March 3, 2015

FEMA LOMC Clearinghouse  
Attention: LOMR Manager  
847 South Pickett Street  
Alexandria, VA 22304-4605

**RE: Case No. 15-06-0805R**  
**Response to Request for Additional Information**

Geom: PINO ARROYO - EXST 2
RS = 2400

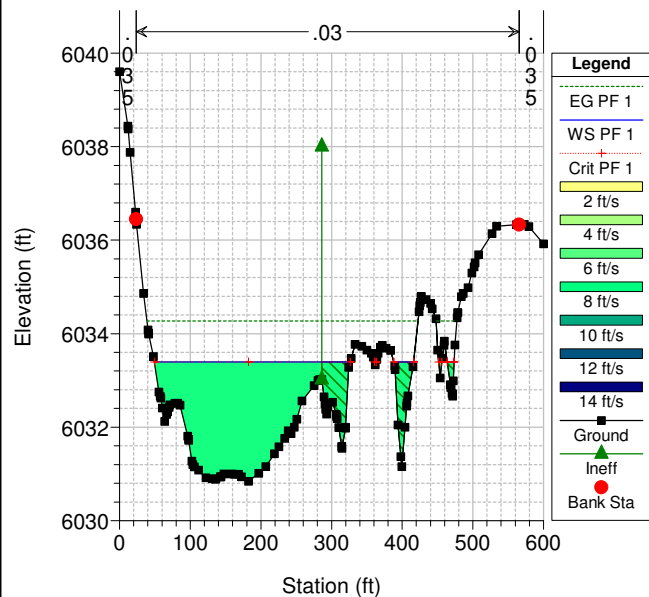
7. *"Our review revealed that ineffective flow areas are required to be included at Cross-Sections 2300 and 2400 in the proposed conditions model and Cross-Sections 1462.03, 1481.63, 1550, 2300, and 2400 in the submitted existing conditions HEC-RAS model. Please submit the revised models after including ineffective flow area wherever needed."*

I added ineffective flow in those areas.

RS = 1873.47

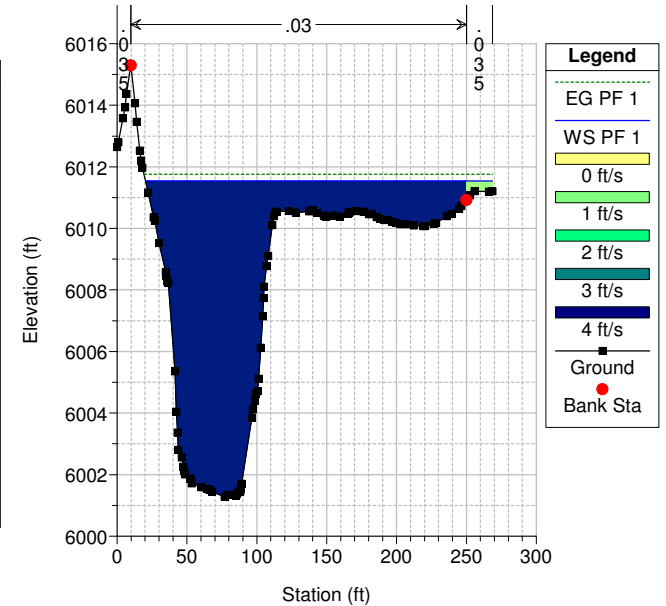
8. *"Our review revealed that the 1-percent-annual-chance (base) Flood Elevations (BFEs) are higher than the end points of Cross-Sections 1873.47, 1086, and 1054.4 in the submitted existing conditions HEC-RAS hydraulic computer model and Cross-Sections 1086 and 1054.4 in the submitted proposed conditions HEC-RAS mode along Pino Arroyo. The use of vertically extended cross sections might both overestimate the BFEs and underestimate the width of the base floodplain. Please revise the cross-section geometry coordinates so that the end points of all cross sections are equal to or extend higher than the corresponding BFEs, or provide documentation that quantifies the amount of split flow that would occur if the cross-sections were not extended and the extent of all flow breakouts."*

Downstream of Tramway Blvd (in the existing conditions only) Cross Section 1873.47 would divert into the portion of the Pino Arroyo that rejoins the main flow just upstream of the dam. This area is problematic. The analysis area would more than double in width if I ensure that there are no overflow locations. The cross-sections would be so wide they would intersect each other. I believe this is an overly complicated solution for this minor concern.

PINO ARROYO - EXISTING CONDITIONS Plan: Plan 15 4/28/2015
Geom: PINO ARROYO - EXST 2

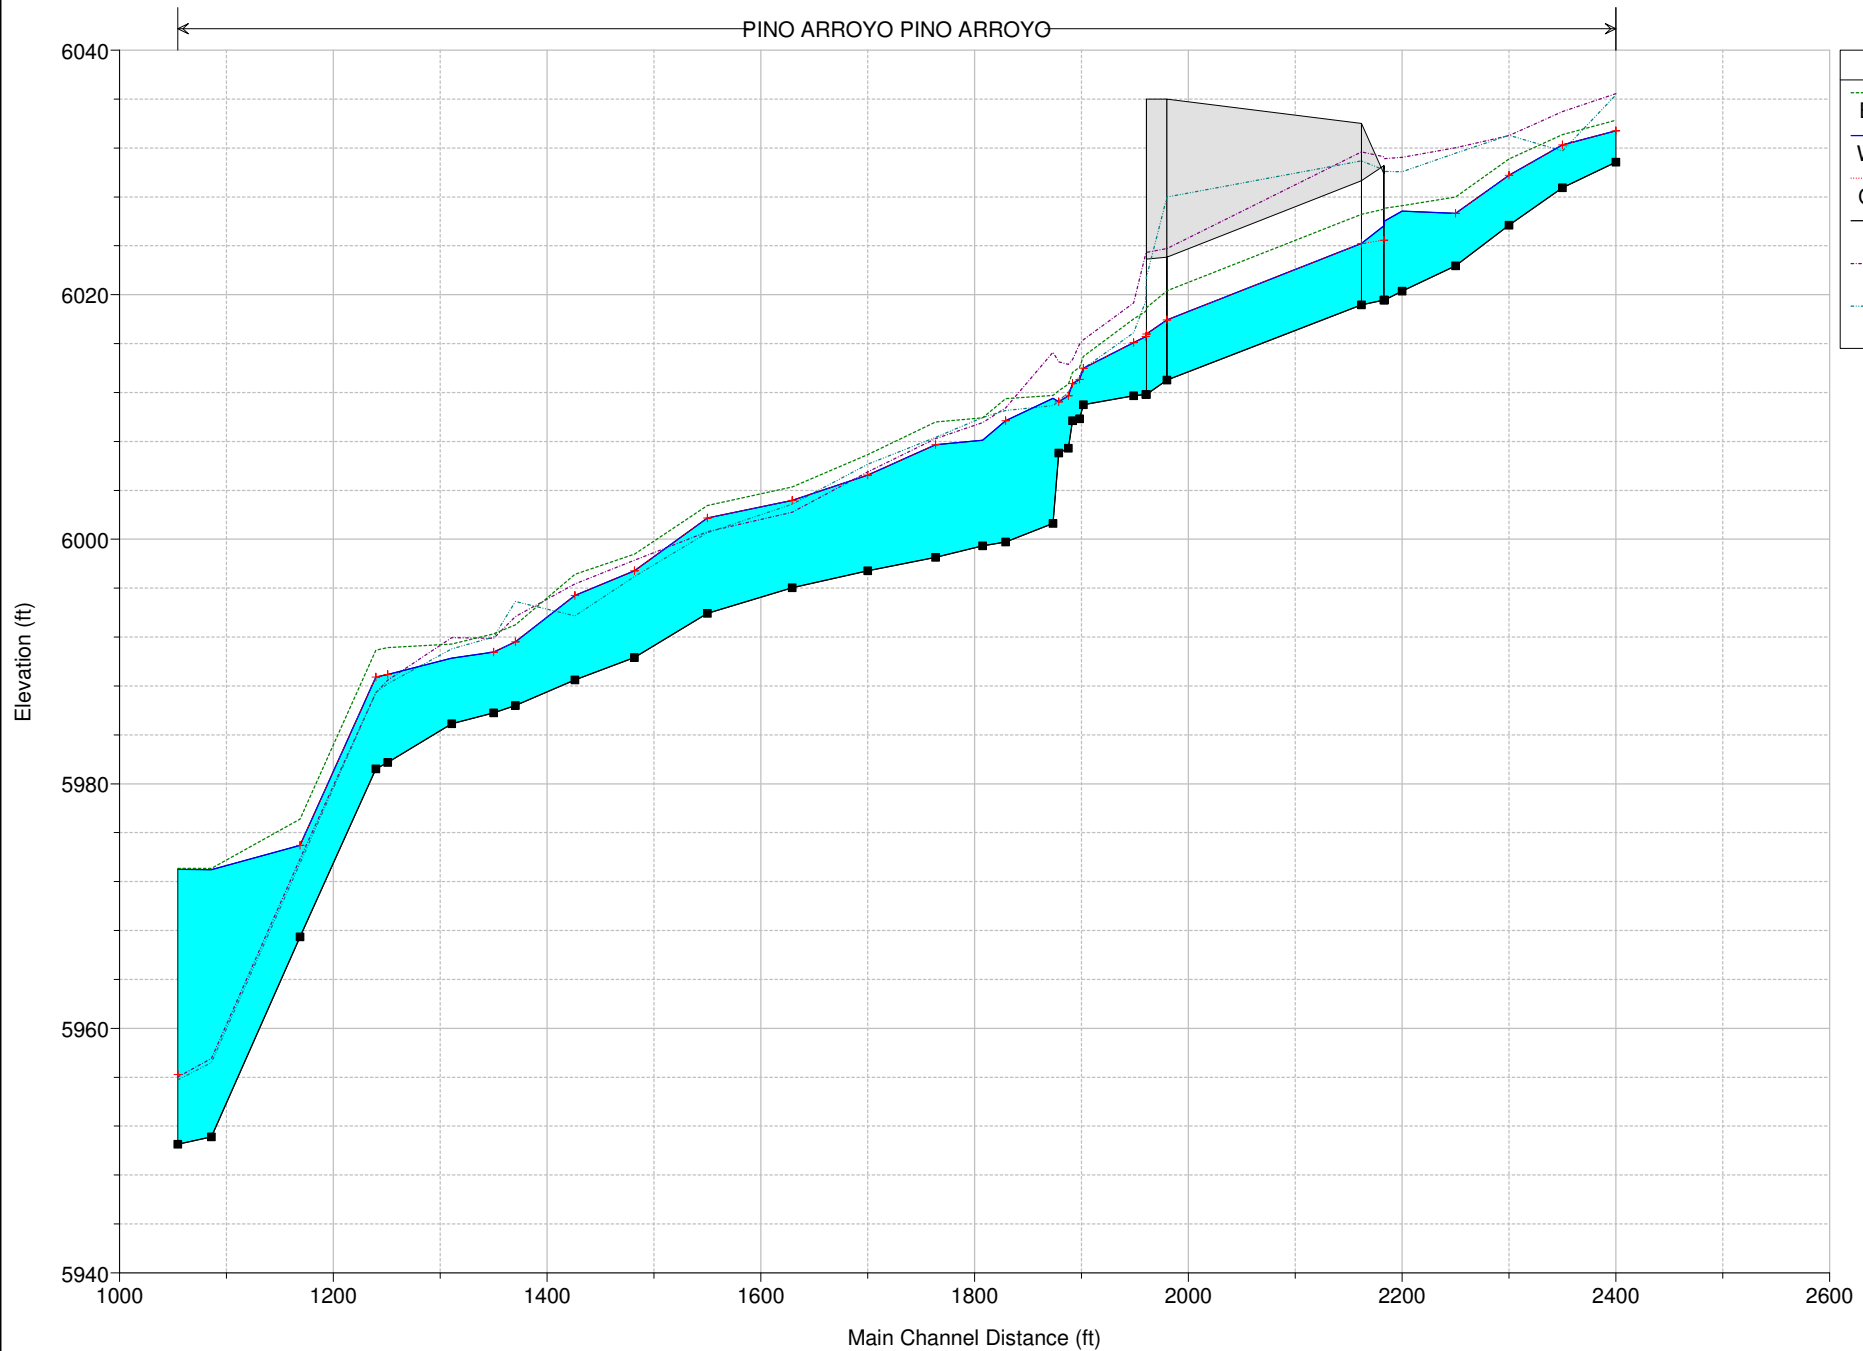
9. *“Our review revealed that the submitted existing and proposed conditions hydraulic models were run using the mixed flow regime. FEMA accepts base floodplain boundary delineations based on supercritical flow depths only for concrete-lined, engineered channels. Because the existing and proposed channel are not concrete lined, critical depth is the minimum depth permissible to map the base floodplain boundary delineations along this reach. Please revise the hydraulic analysis for this portion of the channel using subcritical modeling, or provide an explanation for not using subcritical modeling.”*

According to the cHECK-RAS results “The profile is computed as mixed flow regime. It is acceptable if part of the stream is an engineered channel. For Flood Insurance Studies a subcritical flow regime should be selected, for natural streams. Supercritical flow regime should be selected if the entire stream is an engineered channel. The flow regime should be changed appropriately or justify the selection of mixed flow regime.”

Both the existing and proposed conditions are a mix of lined and natural channel.

In the existing condition the culvert under Tramway Blvd and the concrete rundown into the Pino Dam are lined channels in a supercritical condition. The remaining portions are natural. There is hydraulic jump upstream and downstream of the existing box culvert.

For the proposed condition the 70'± portion upstream of the existing condition is a natural channel. Everything else is either in a culvert or a lined channel. There is hydraulic jump upstream of the existing box culvert.

Per the HEC-RAS User's Manual, hydraulic jump is another reason to use the mixed flow regime. Mixed flow regime is appropriate for both analyses.
